Parks and Wildlife

November 30, 2018

Re: Environmental Review for the Proposed Grazing Yak Solar Project in El Paso County, Colorado

FENCE DETAIL
NTS

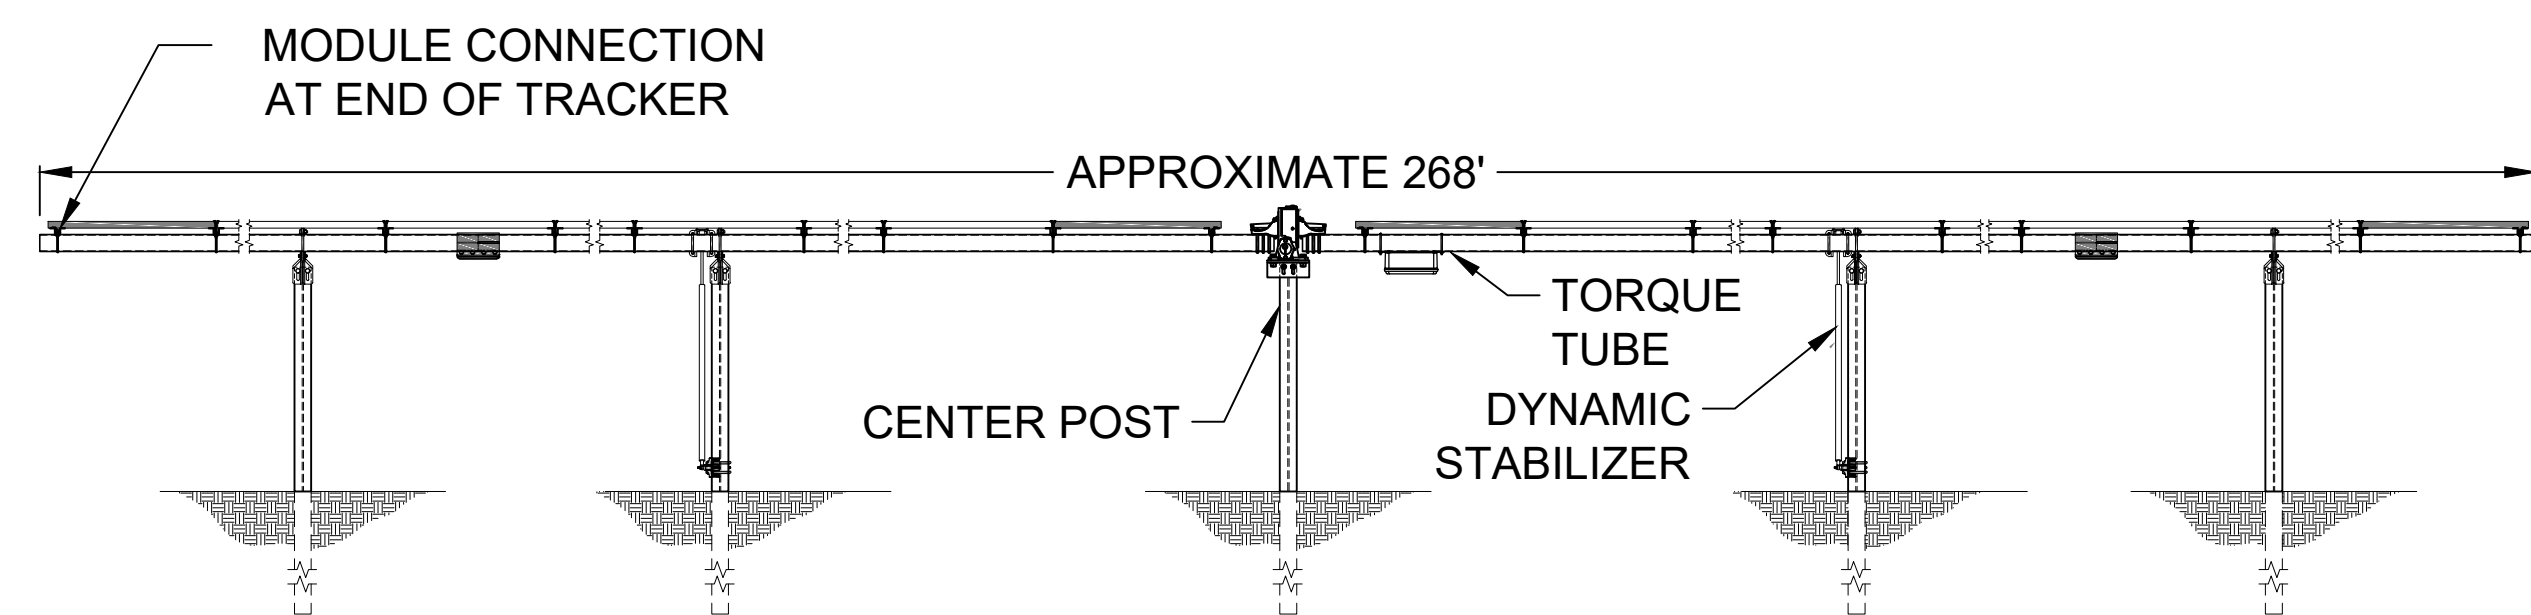
Fencing: CPW is aware that the solar project area will include security fencing. The typical specifications for security fencing make this fence type exclusionary for most wildlife. In these cases CPW requests that the project design adhere to the recommendations for exclusionary fencing that are safe for wildlife. The CPW document "Fencing with Wildlife in Mind" is available at our website and we would be happy to answer questions about fencing specific to this project. For any installed fencing CPW recommends an 8 foot fence with a smooth top to the fence (e.g., no top barbed wire or exposed metal rods) to prevent wildlife from impaling themselves.

CPW would like the opportunity to review final fencing plans when they are available. If wildlife exclusion fencing is installed CPW would request that efforts also be taken to avoid entrapping wildlife within the facility during construction of the fence and that the solar facility is checked regularly post-construction, or structures are installed to allow animals to escape, in the unlikely event that a deer or other wildlife become trapped in the facility. CPW also recommends that any security lighting be designed to minimize light pollution and take into consideration lighting initiatives to reduce impacts to wildlife.
